# Summary of Comments on P:\100\100.067\constr\street \100.067-COVER-street-STM C0.1 (1)

STM LAT "O" PROFILE

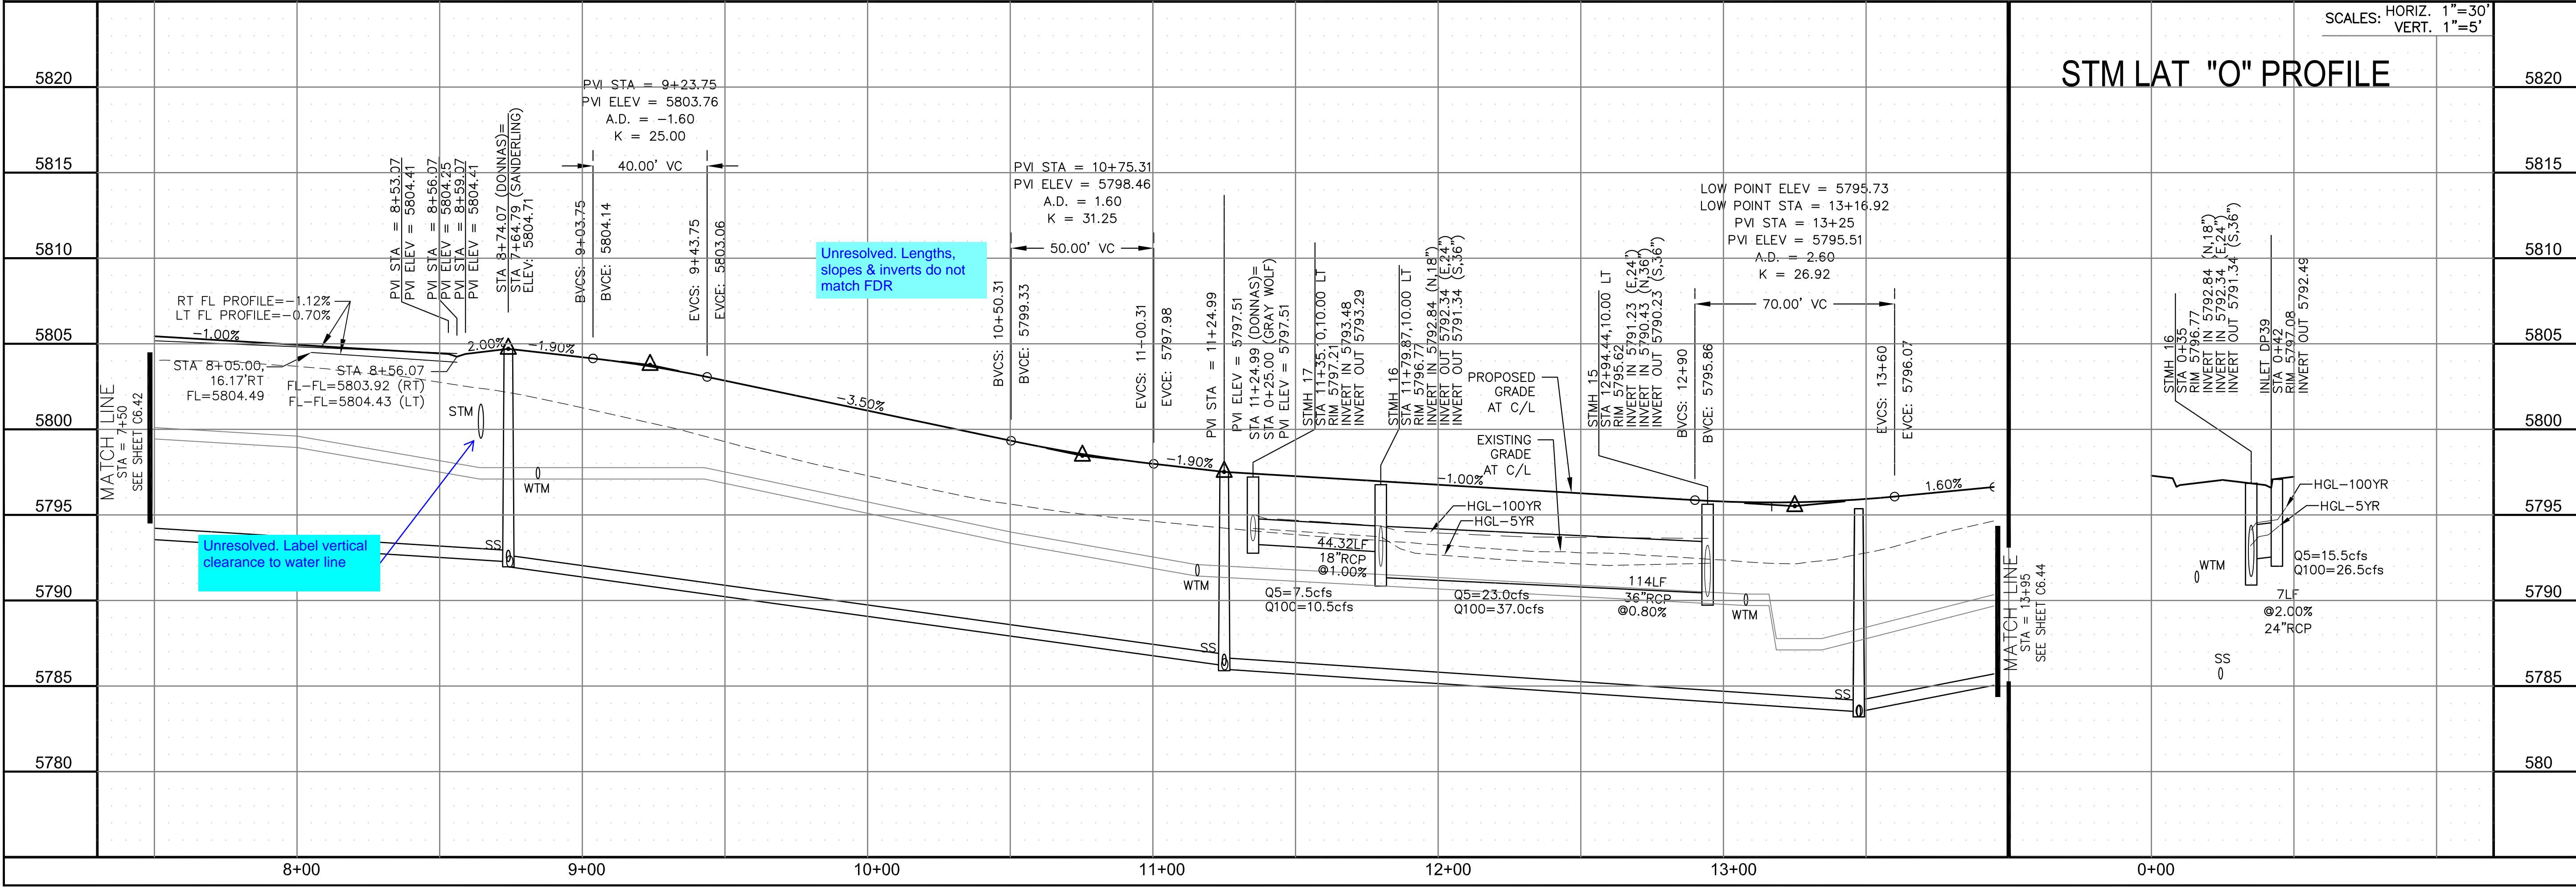
- Author: lpackman Subject: Text Box Date: 5/3/2022 8:56:10 AM  
Unresolved. Lengths, slopes & inverts do not match FDR
- Author: RSchindler Subject: Sticky Note Date: 6/3/2022 8:26:08 AM  
MODEL UPDATED
- Author: lpackman Subject: Text Box Date: 5/3/2022 8:55:49 AM  
Unresolved. Lengths, slopes & inverts do not match FDR
- Author: RSchindler Subject: Sticky Note Date: 6/3/2022 8:25:50 AM  
MODEL UPDATED

MERIDITH RIDGE WAY

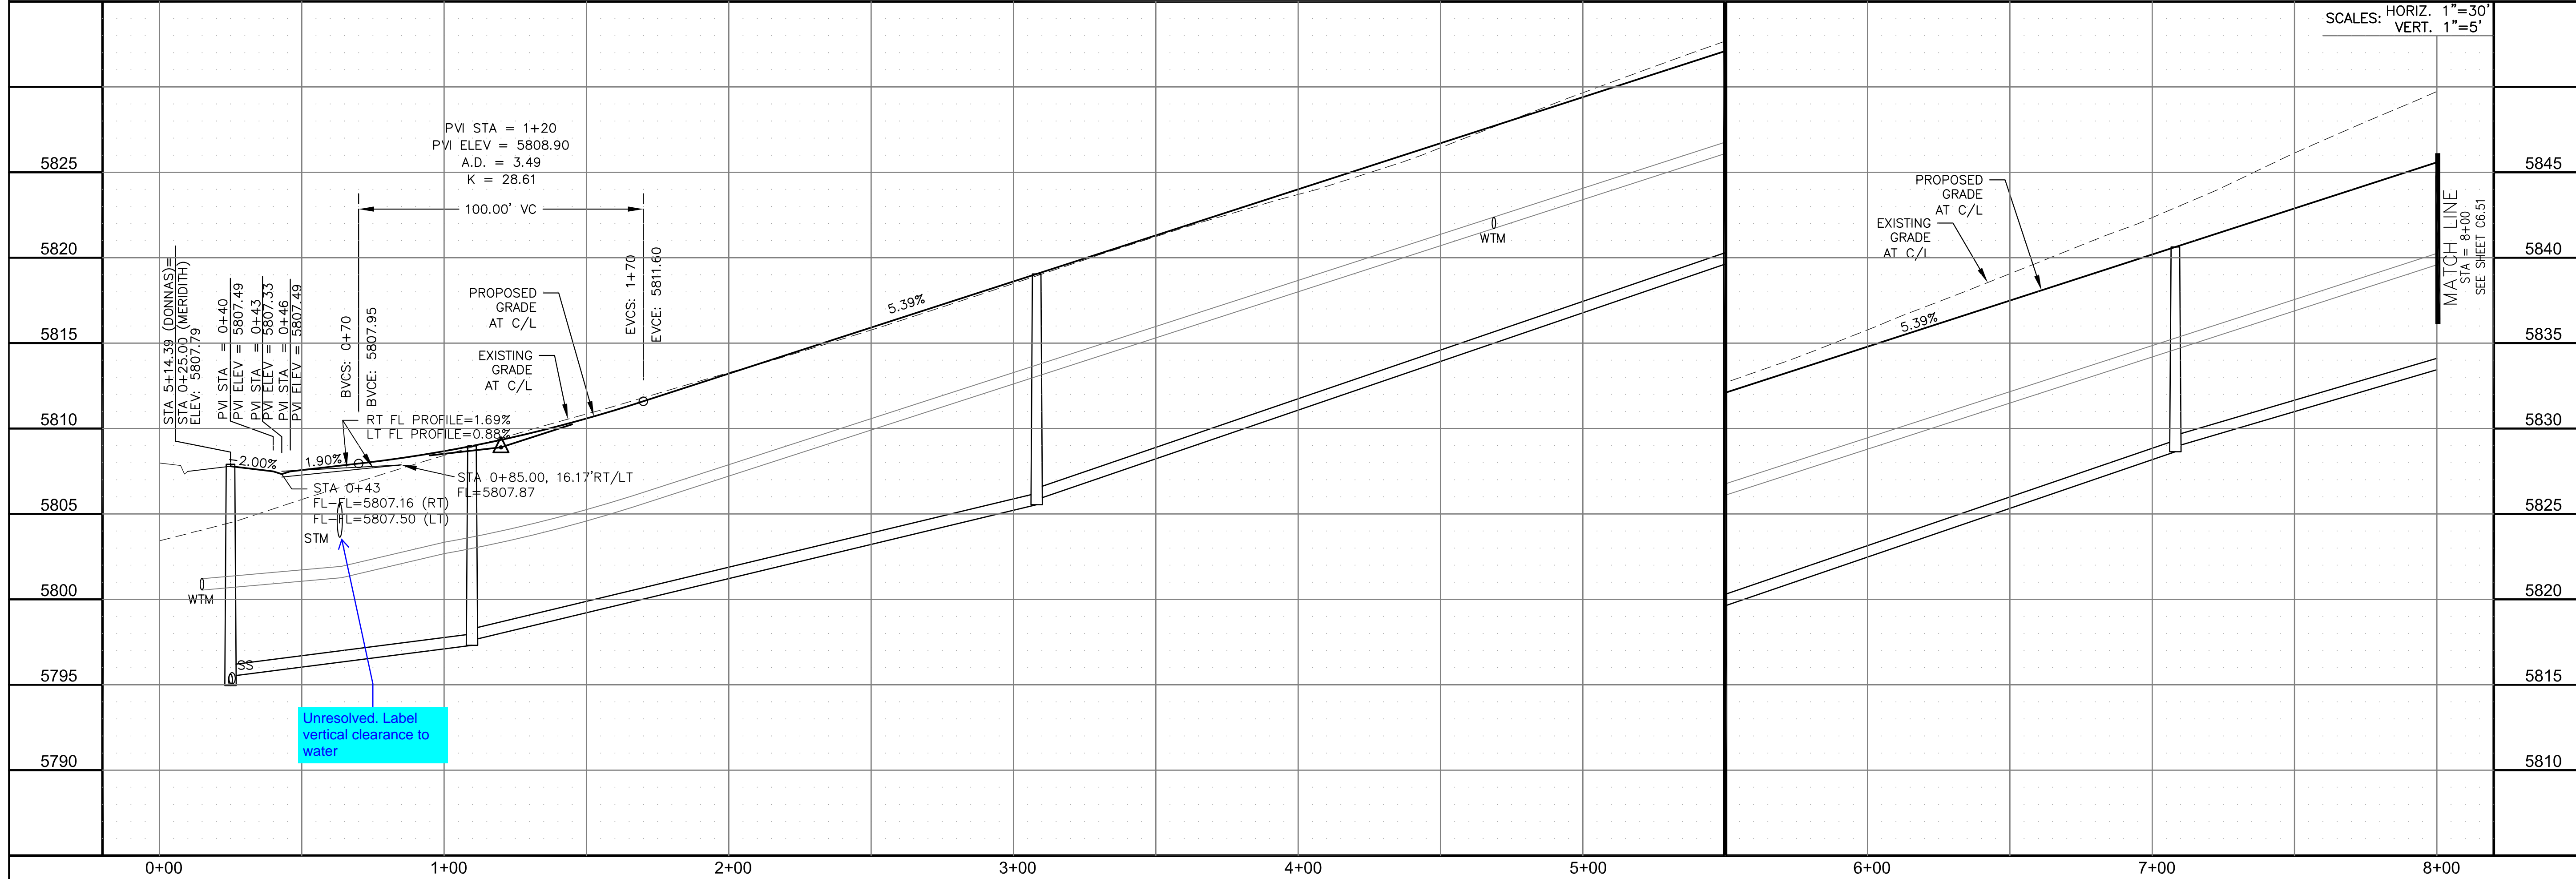
Unresolved. Label vertical clearance to water line

Author: RSchindler Subject: Sticky Note Date: 6/3/2022 8:40:17 AM  
labeled

SHEET NUMBER C6.55

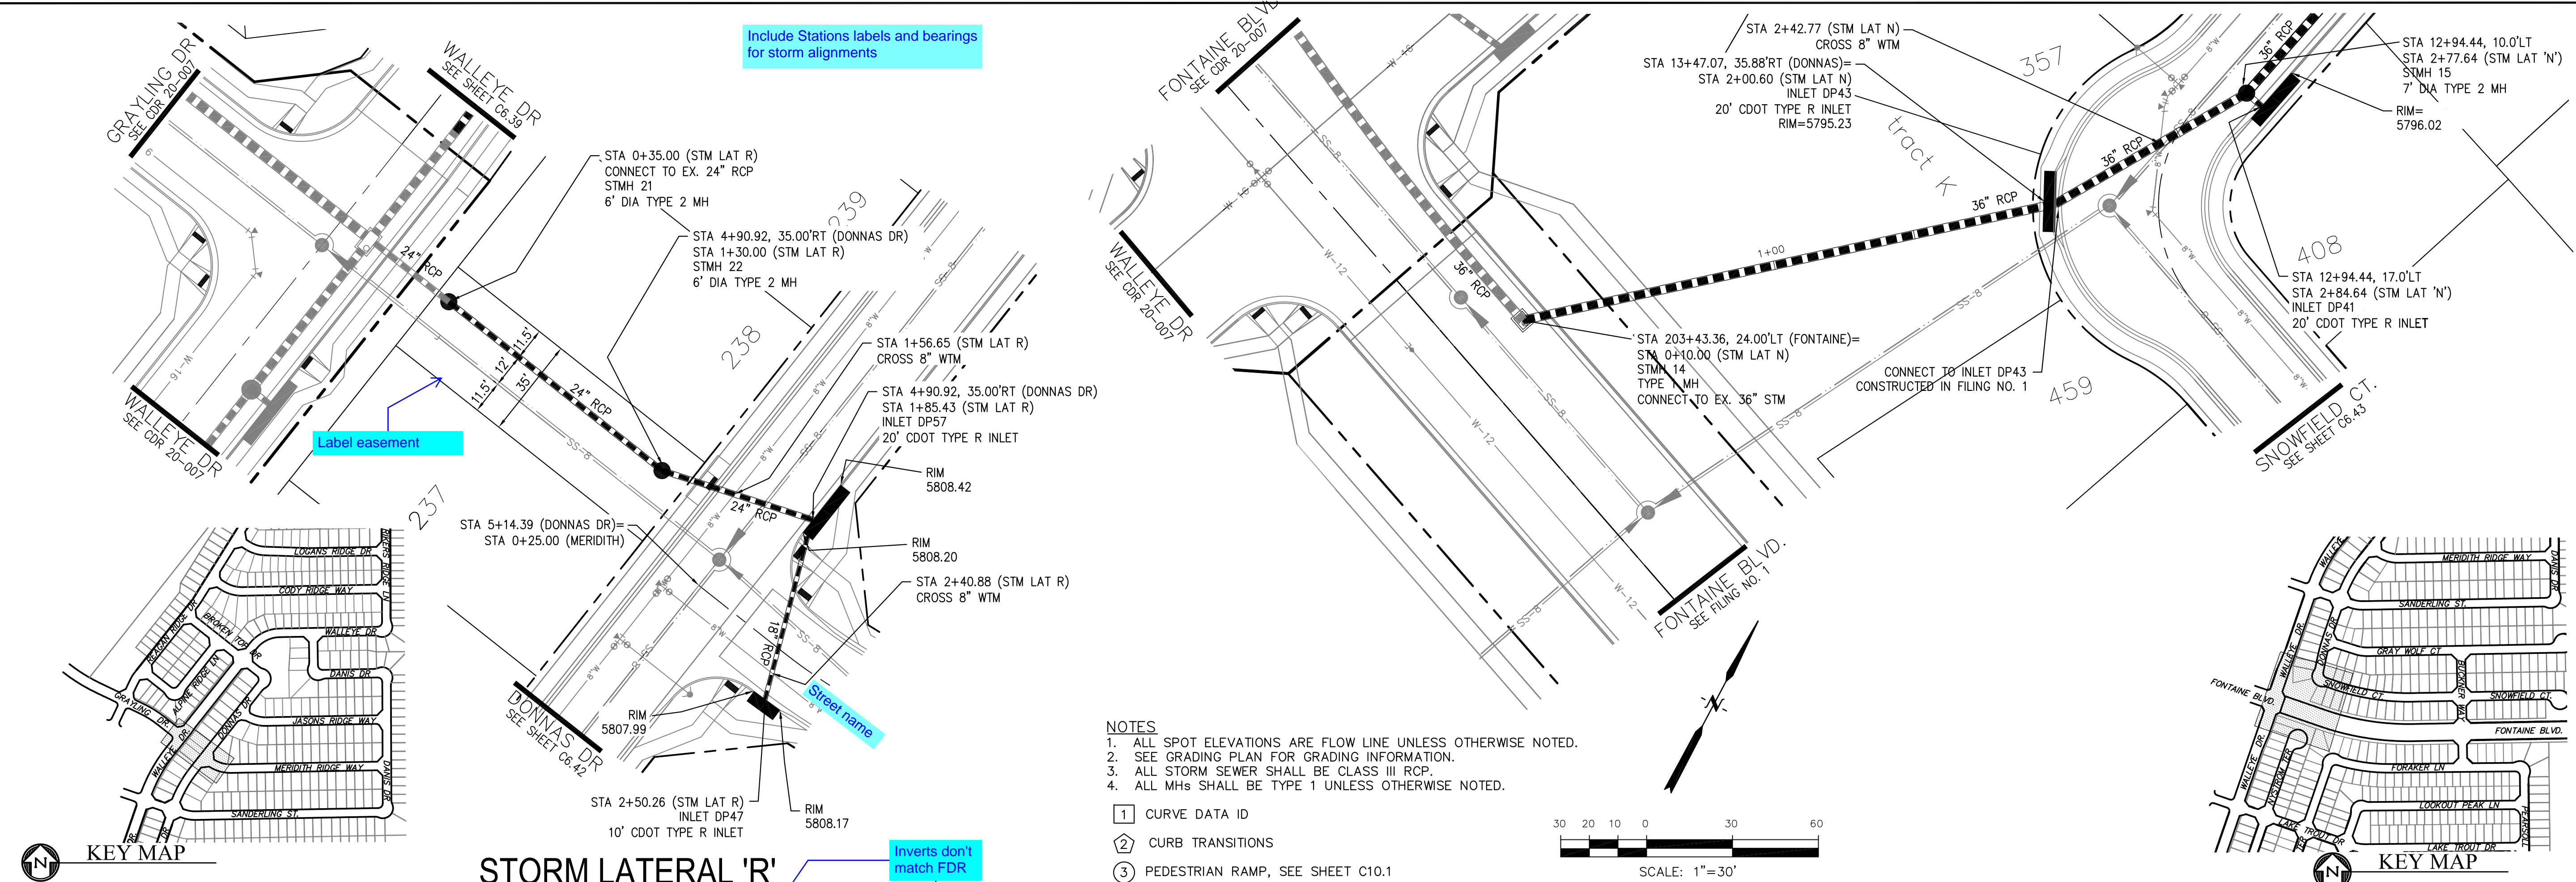
Unresolved. Need to show how proposed grading ties into existing ground

Author: RSchindler Subject: Sticky Note Date: 6/3/2022 8:48:30 AM  
grading extends beyond profile.
